Lake House - Corrections Response Letter

Building Plan Reviewer: **City of Mercer Island**

Response to: 2012-200-SUB-PLANS
Dated: April 1st, 2021
Permit #: 2012-200
Project address: 3310 97th Ave SE
Mercer Island, WA 98040

Project: Lorenzini Lake House
 Permit #: 2012-200

LEGEND

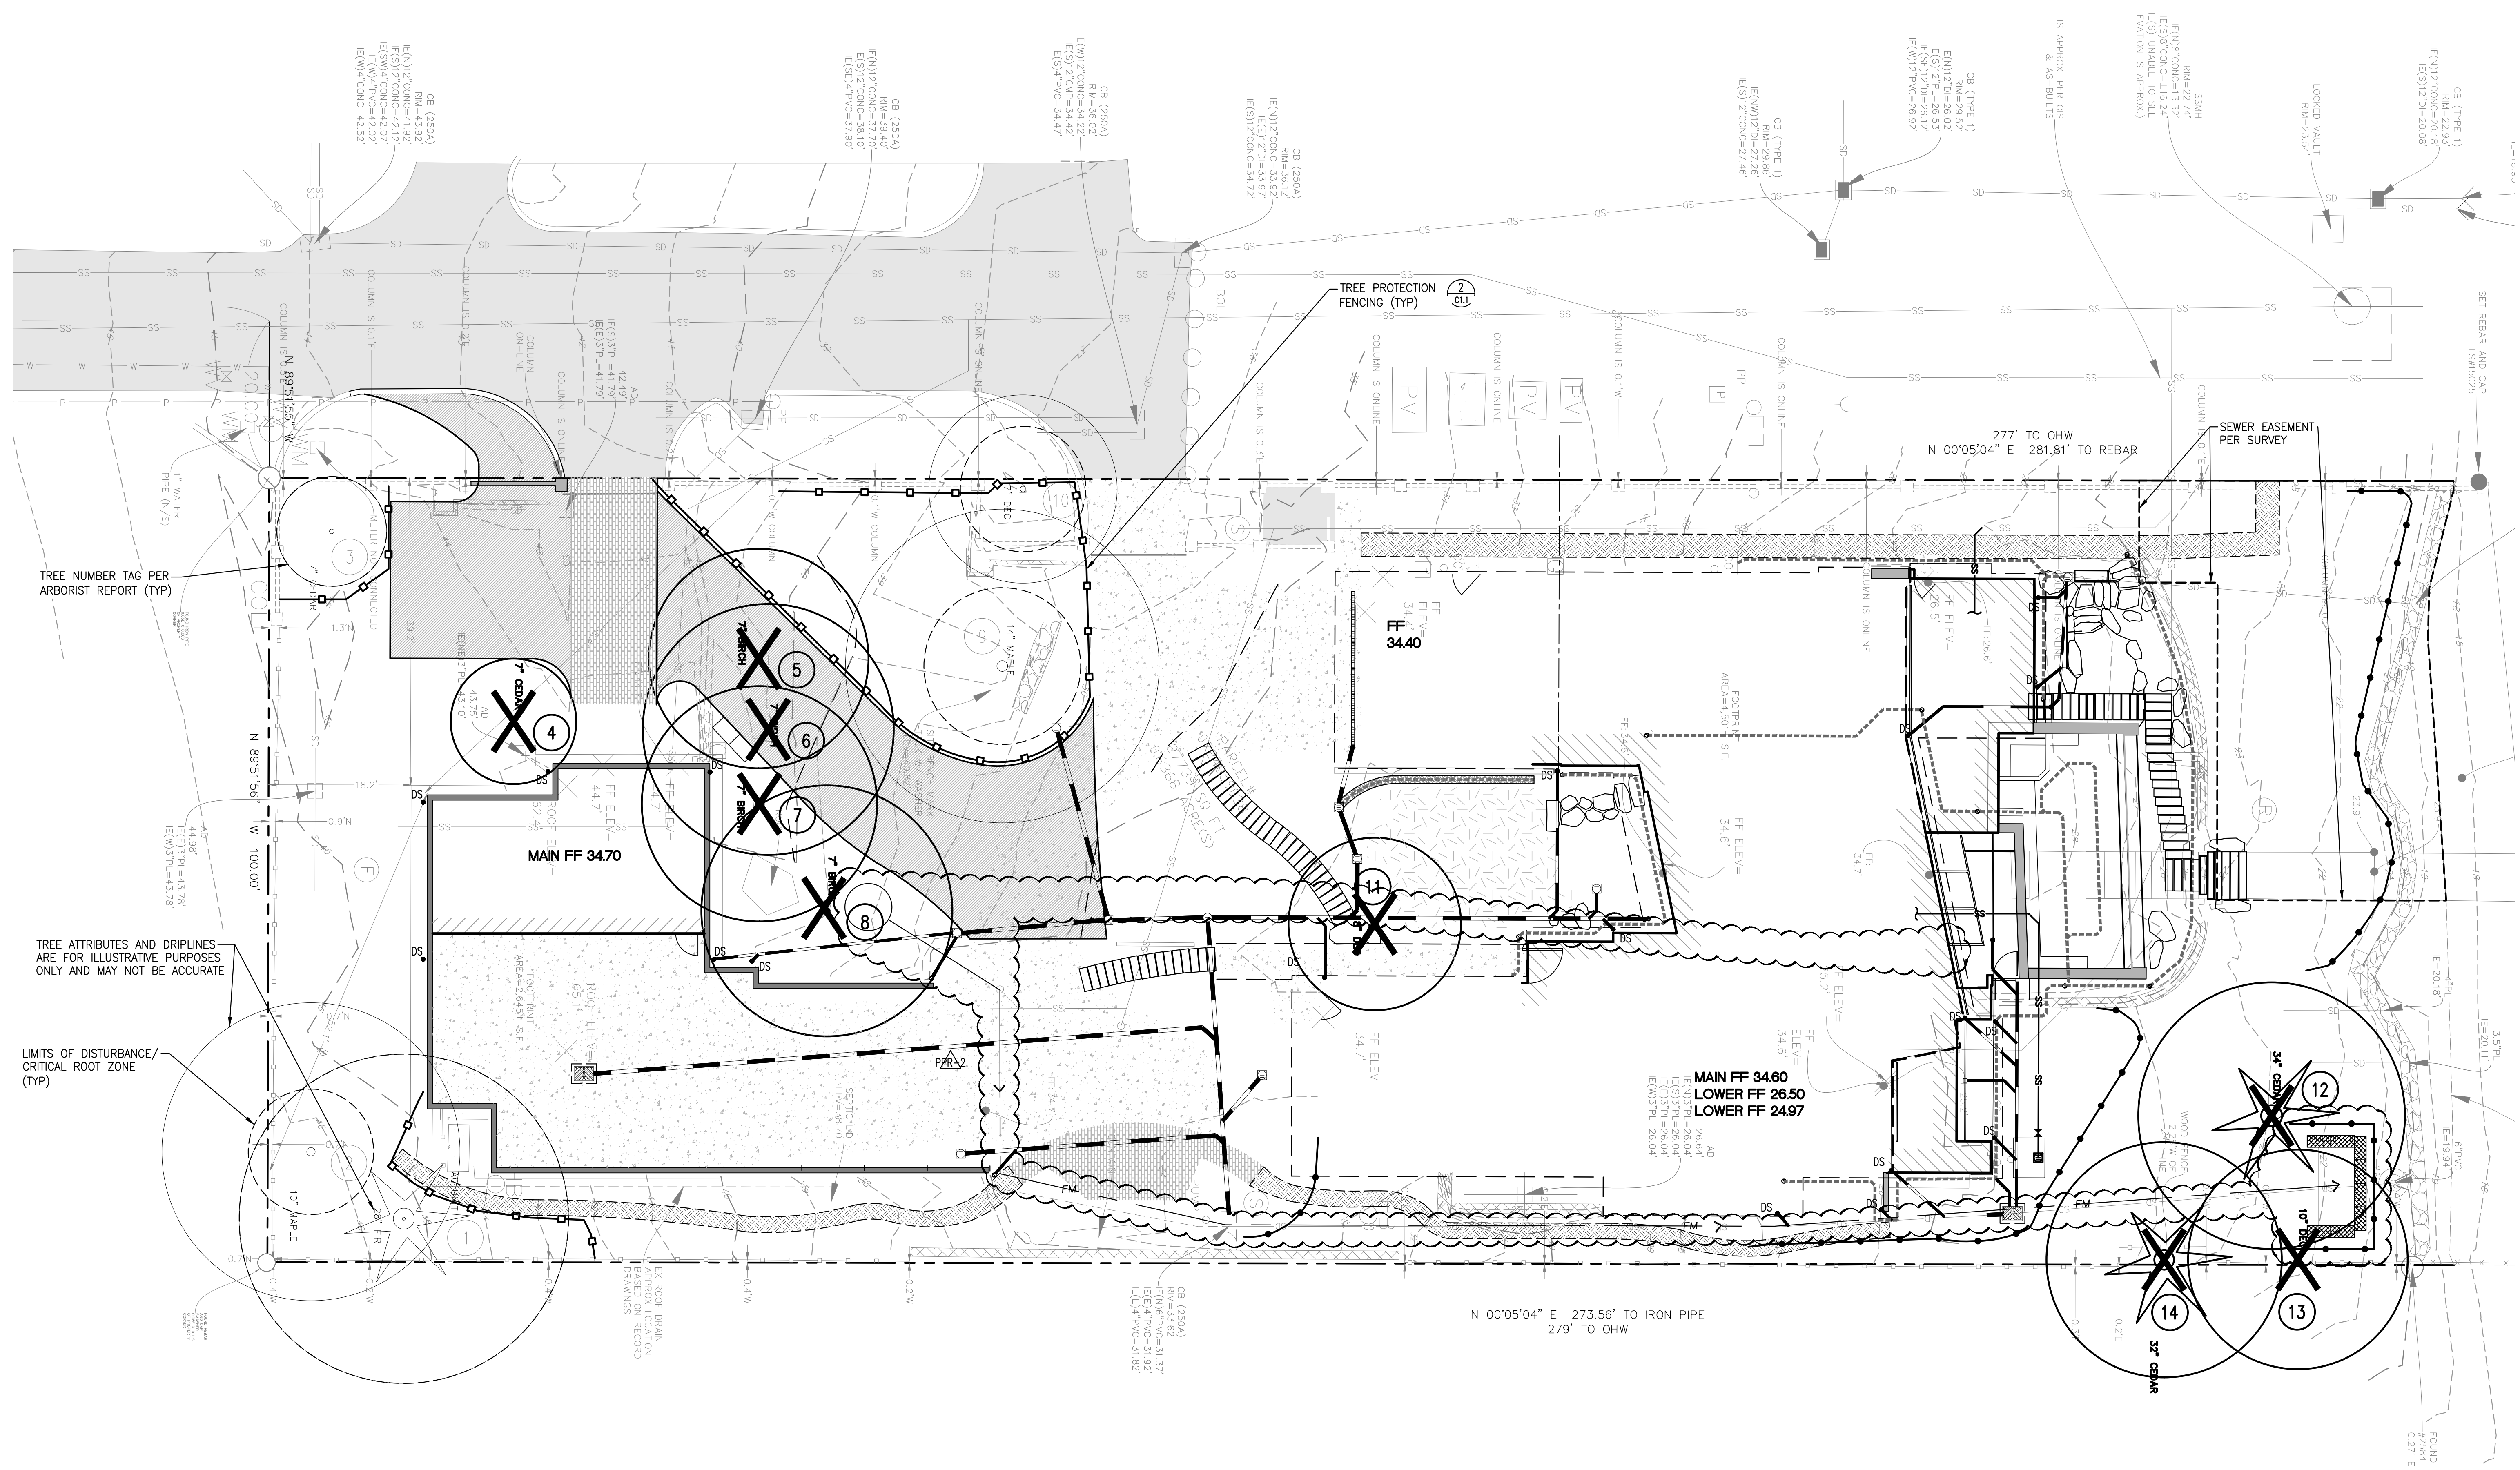
Comments –	LPD Response
<p>1. Planning Review - Page 5</p> <p>Please label and show this easement on the site plan, civil, and tree plans.</p>	<p>Sewer easement has been labeled and shown on plan sheet C1.0A TESC, C1.0B Demo, C1.0C tree retention, and C3.0 paving and utilities.</p>
<p>2. Civil Review - Page 6</p> <p>Remove fence out of ROW.</p>	<p>Tree protection fencing has been removed out of ROW.</p>
<p>3. Civil Review - Page 10</p> <p>Are you considering to use LID (previous material) to manage the runoffs for this parking area? If so, please provide design in the drainage report and plan (with detail section).</p>	<p>A detail section for the driveway pavers has been added to the plans on Detail 7 Sheet C3.1. A description of the implementation of permeable pavement in this area is included in the previously submitted drainage report.</p>
<p>4. Civil Review - Page 10</p> <p>Can you clarify the section of the existing storm pipe to remain? And add note to say that the entire existing remaining storm system must be video inspected and</p>	<p>A clarification note has been added to sheet C1.0B to save and protect existing storm as well as video inspect the system prior to</p>

SITE PLAN
A1.01

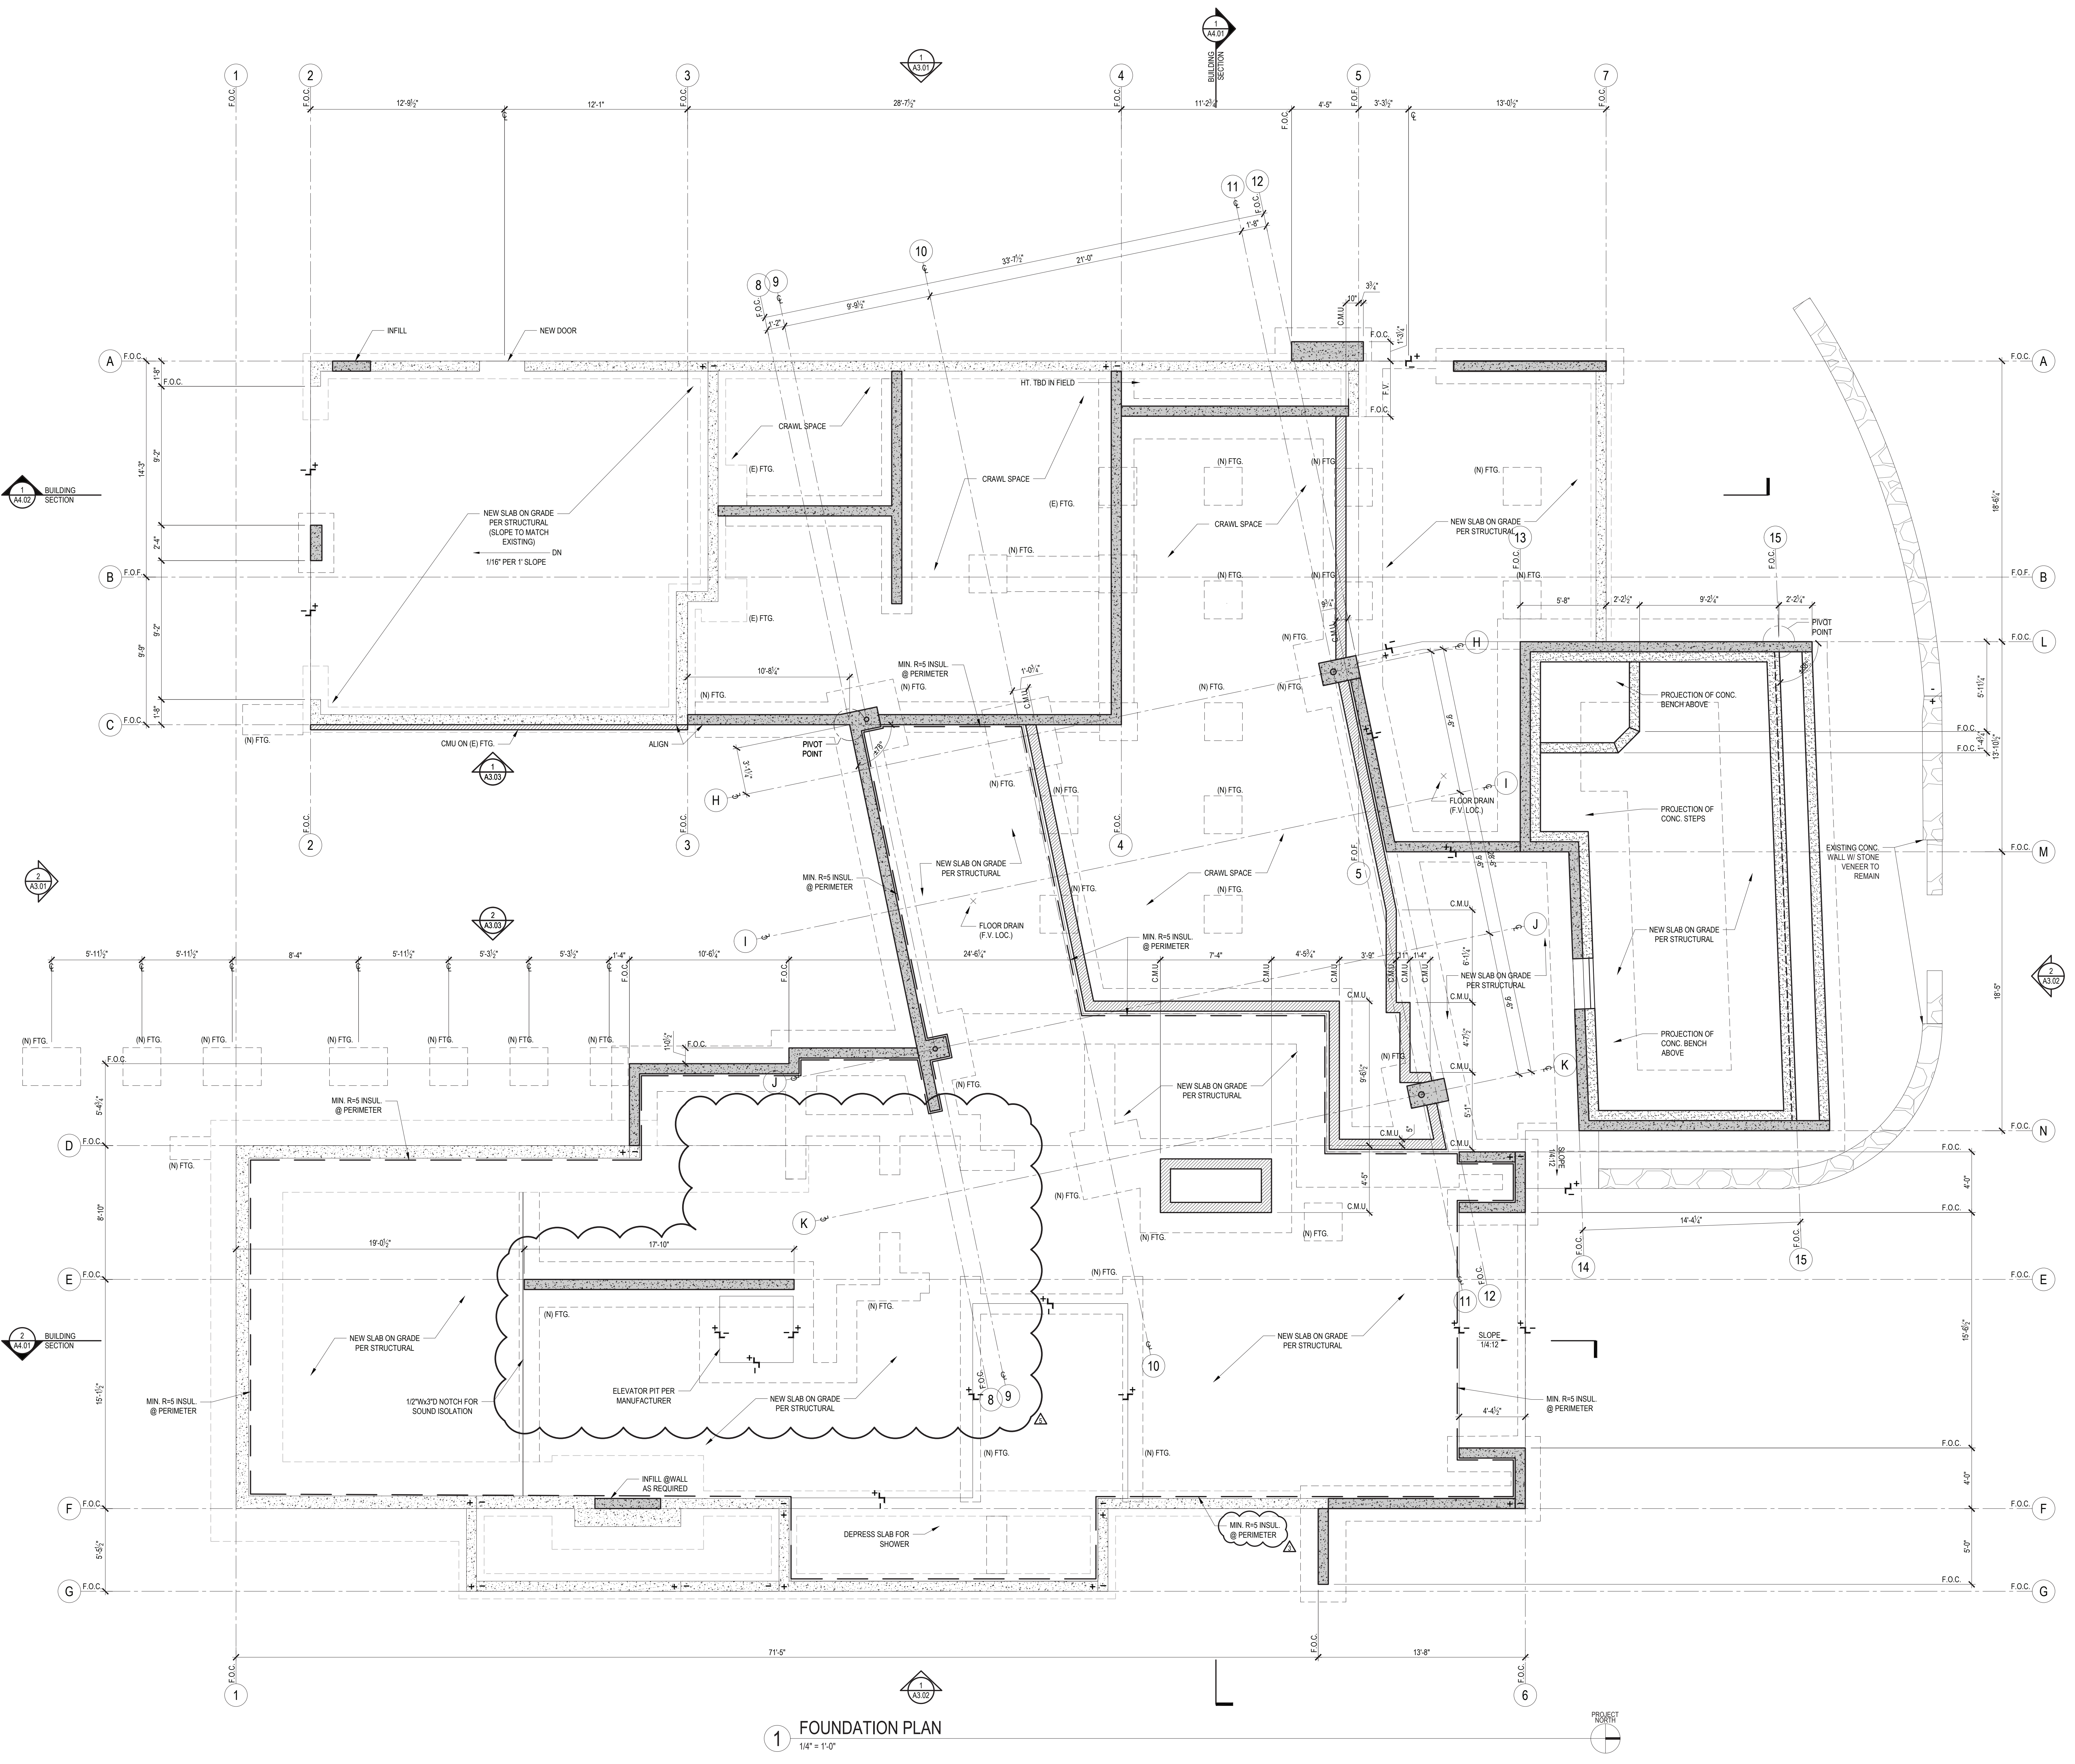
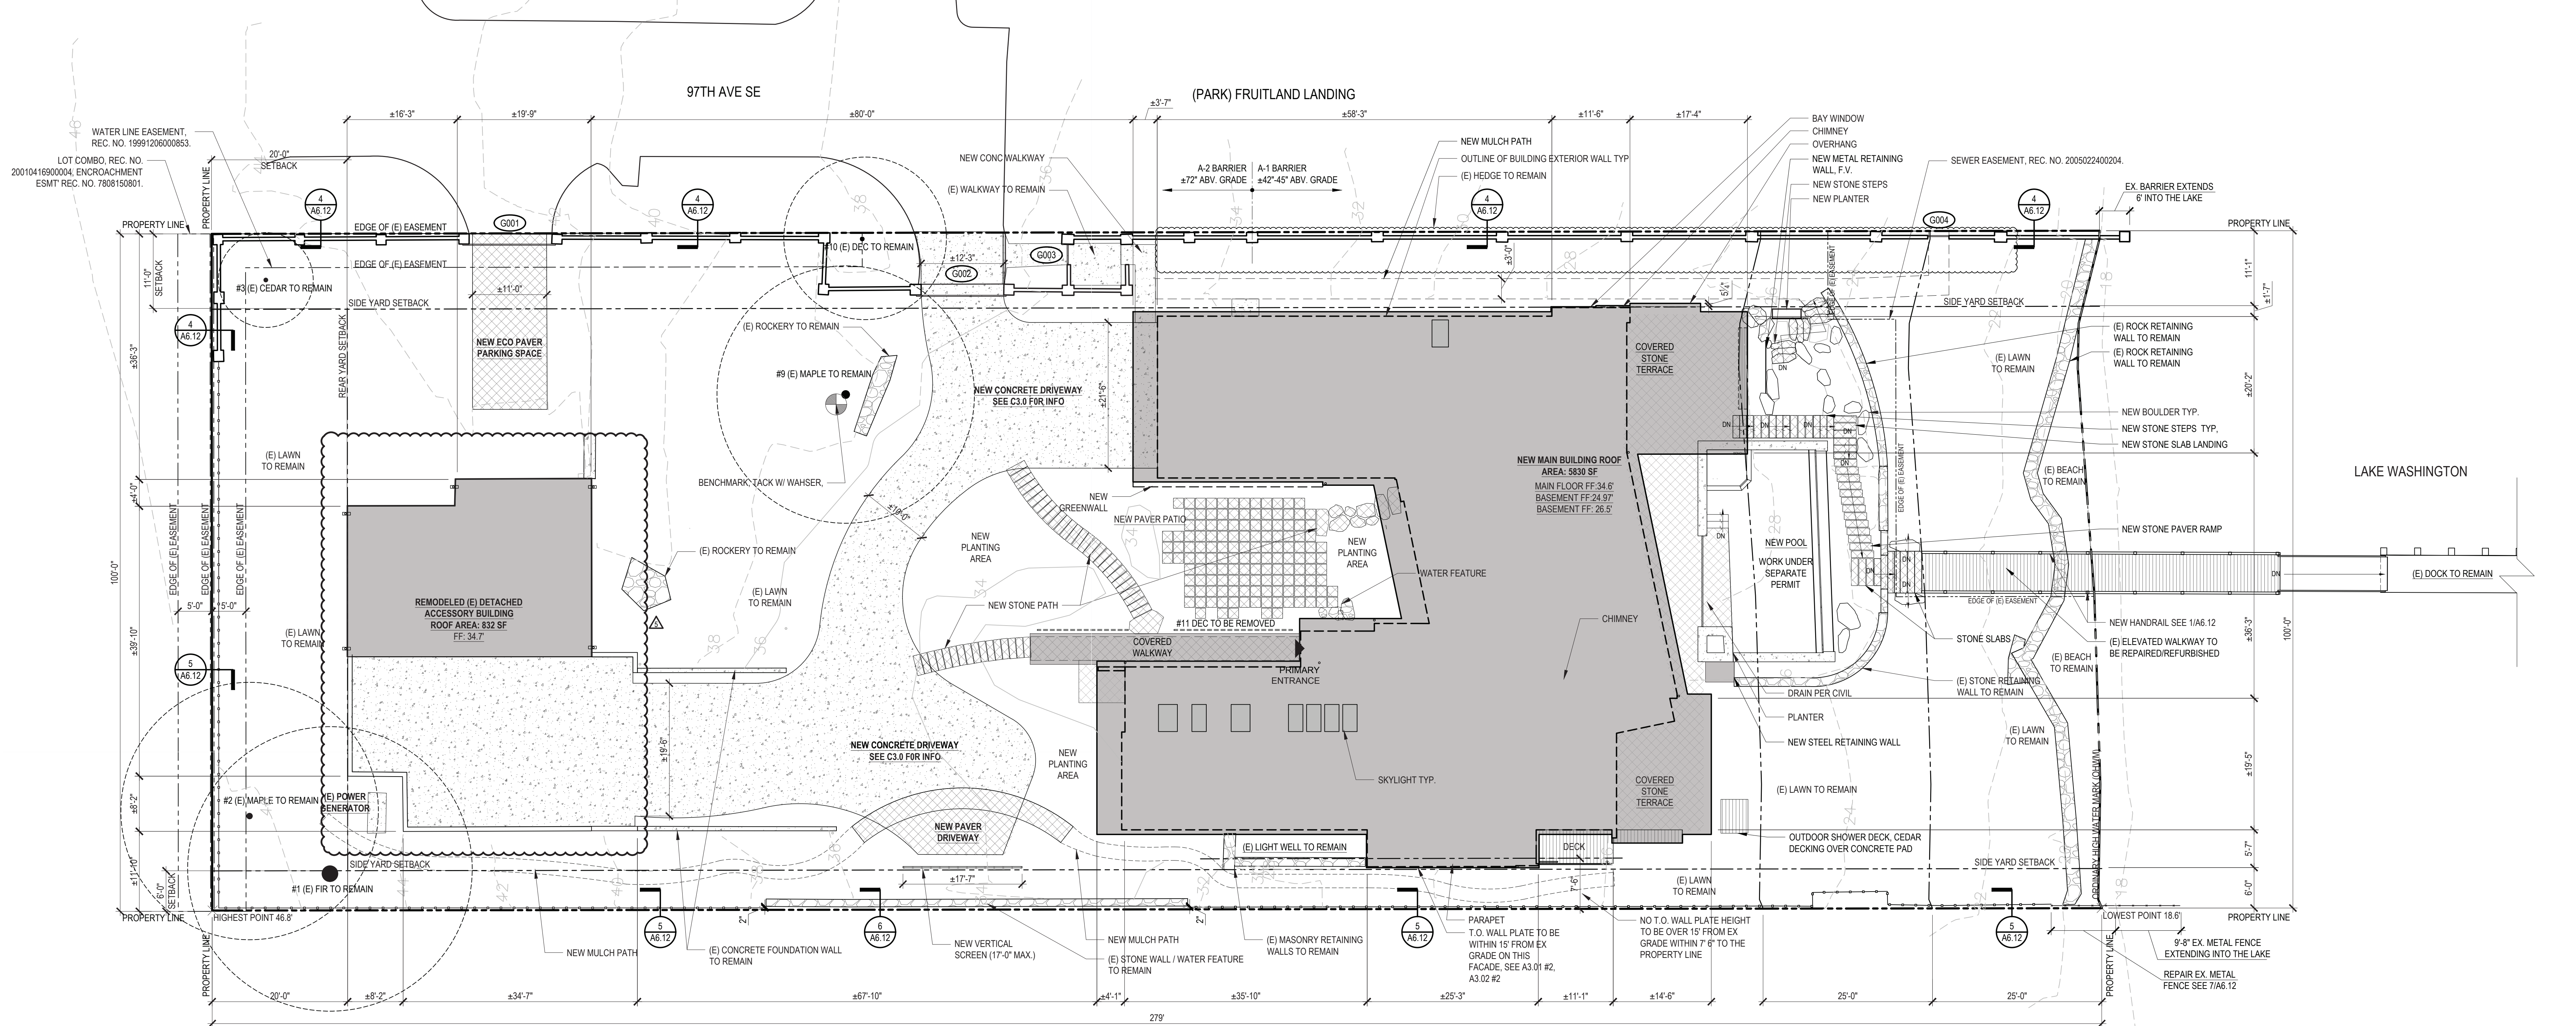
Survey - Please label and show this easement on the site plan, civil, and tree plans.

A1.01 - Please provide a native planting plan for the shoreline. The plantings are required for development over 500sf. Please refer to MICC 19.13.050(K)(4) and figure C.

- **SITE PLAN A1.01 has the note for this easement, no action added**
- **See revised civil drawing sheet**
- **See L1.01 for easement note on the planting plan**
